OXFORDSHIRE COUNTY COUNCIL'S RESPONSE TO CONSULTATION ON THE FOLLOWING DEVELOPMENT PROPOSAL

Application no: 22/01829/OUT

Proposal: Outline (fixing 'Access' only) – redevelopment of Graven Hill D1 Site, including demolition of existing buildings, development of B8 'Storage or Distribution' use comprising up to 104,008 sq. m (GIA), creation of open space and associated highway works, ground works, sustainable drainage systems, services infrastructure and associated works.

Location: Unit D1 Graven Hill, Circular Road, Ambrosden OX26 6HF

Figure 2-4 Indicative Masterplan

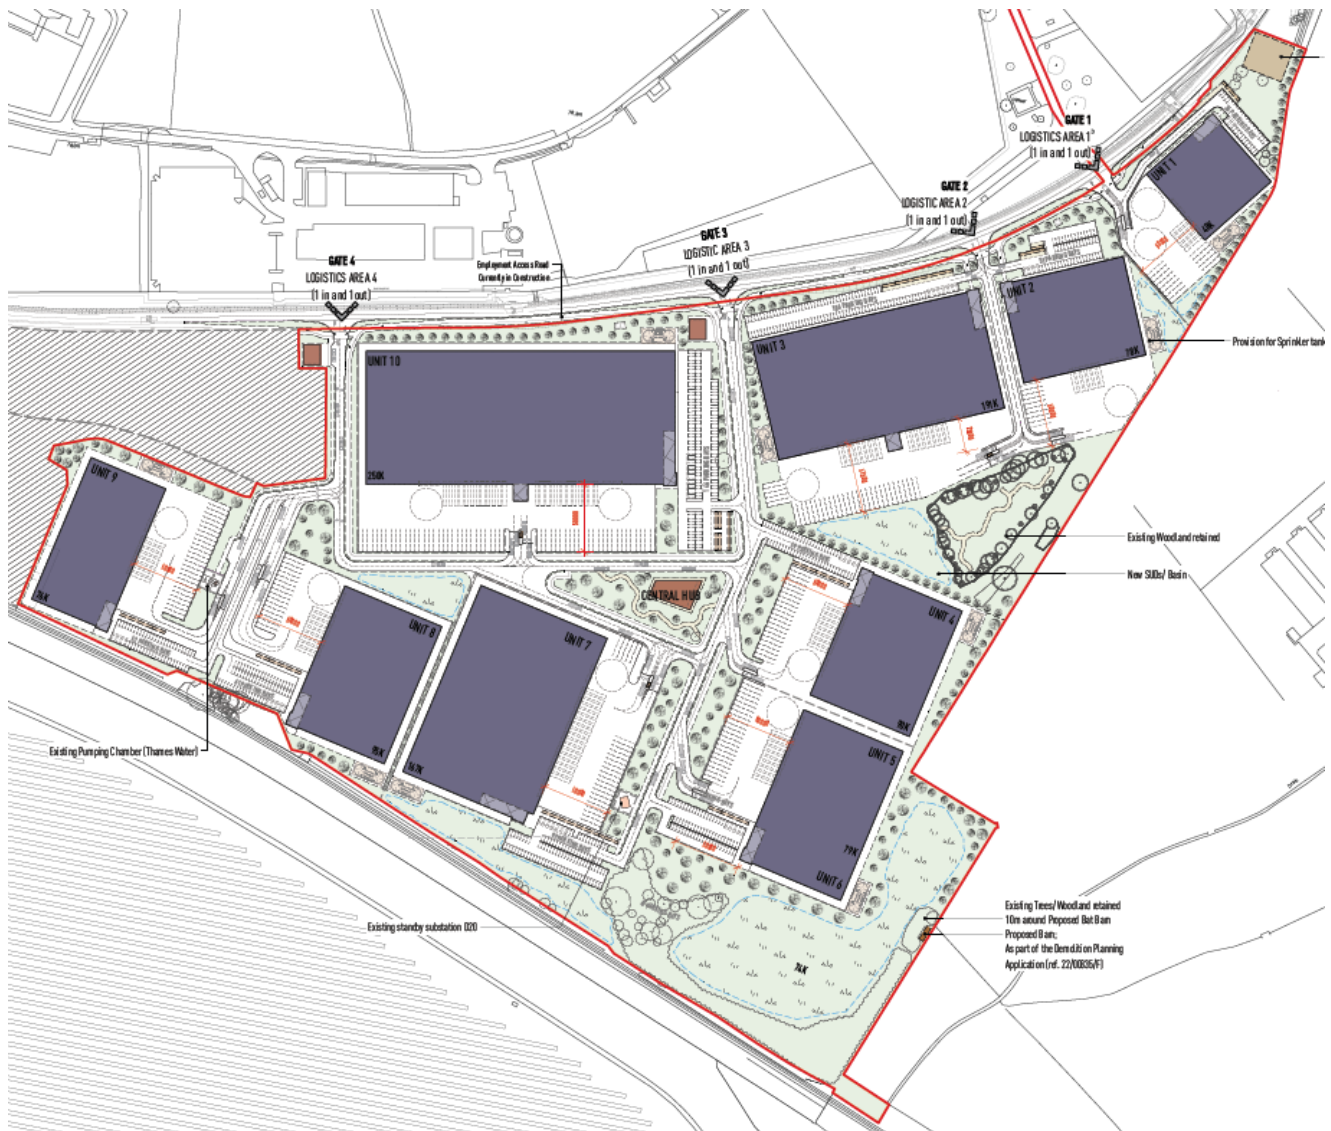
The Indicative Proposed Plan shows the east-west internal road to be a straight length of 300m, while two of the other roads are about 200m long. Deviations or features are typically placed at a maximum spacing of 70m to reduce speeds. Consideration must be given to designing the street layout in order to restrict speeds to appropriate levels.

dig. no. 1923/050/015	rev. C
---------------------------------	------------------

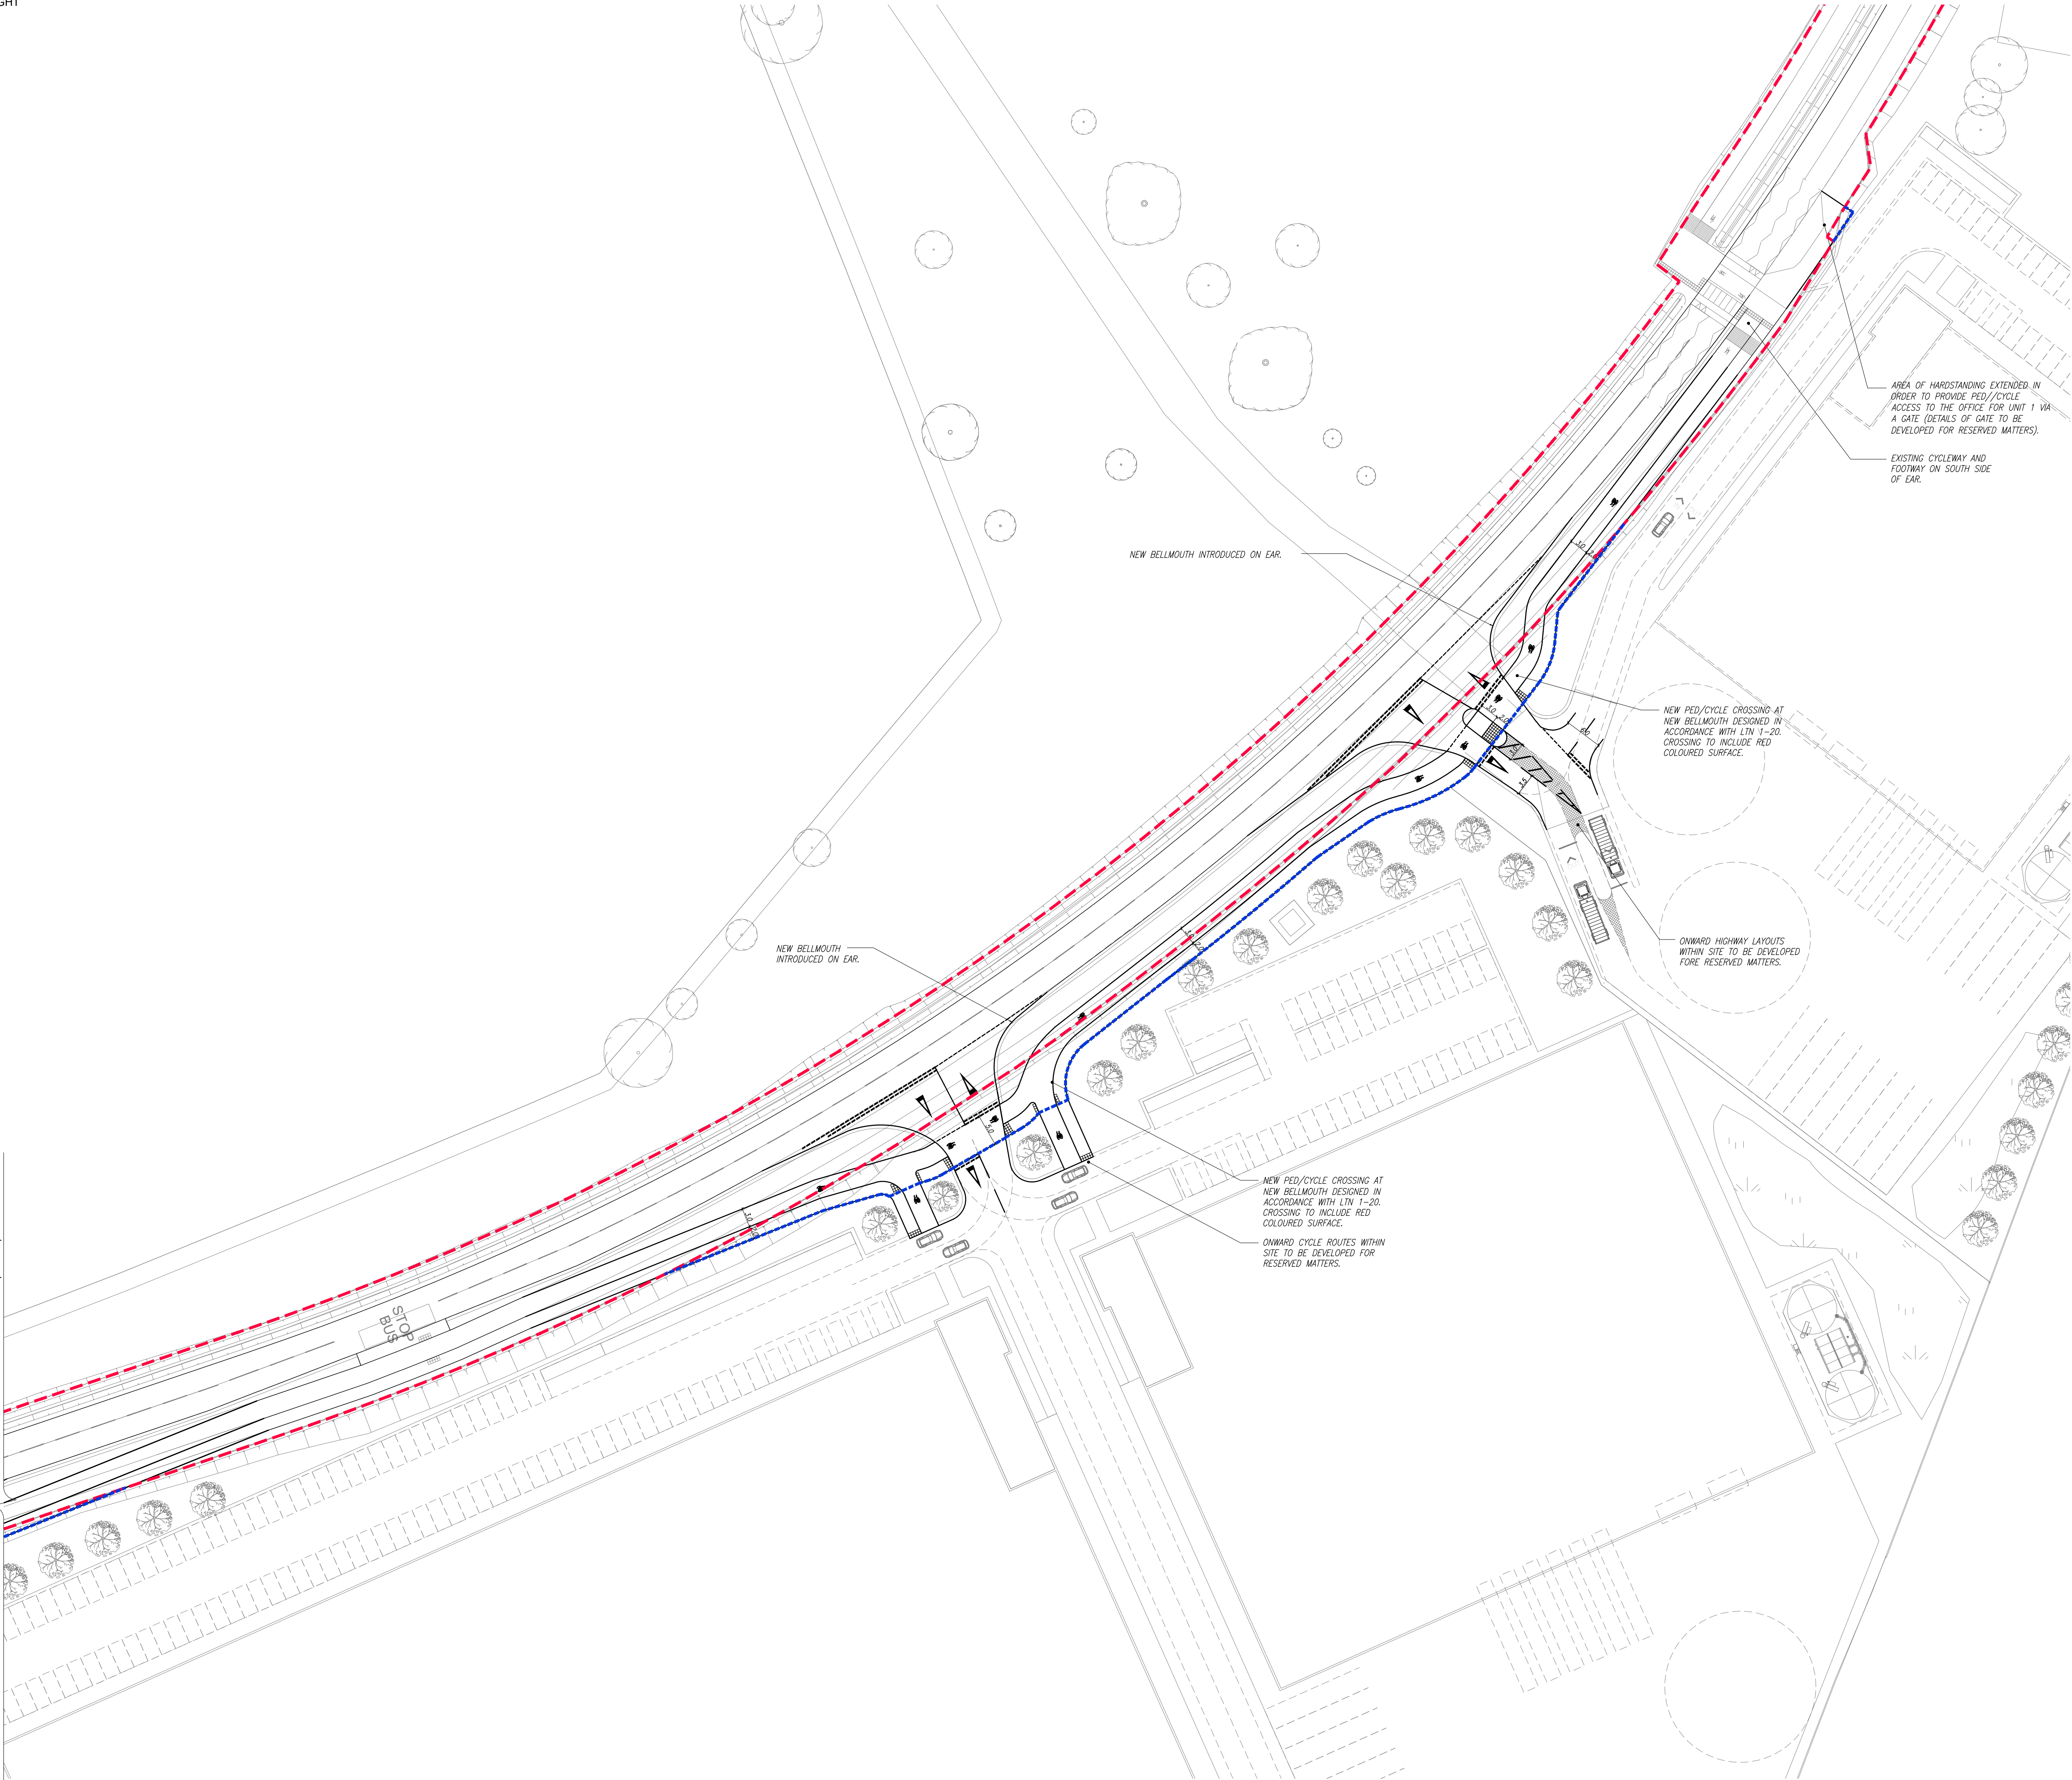
- 4 no. bellmouth site access junctions, as shown indicatively on Alan Baxter drawing nos. 1923/050/015 Rev. C, /016 Rev. B and /017 Rev. B
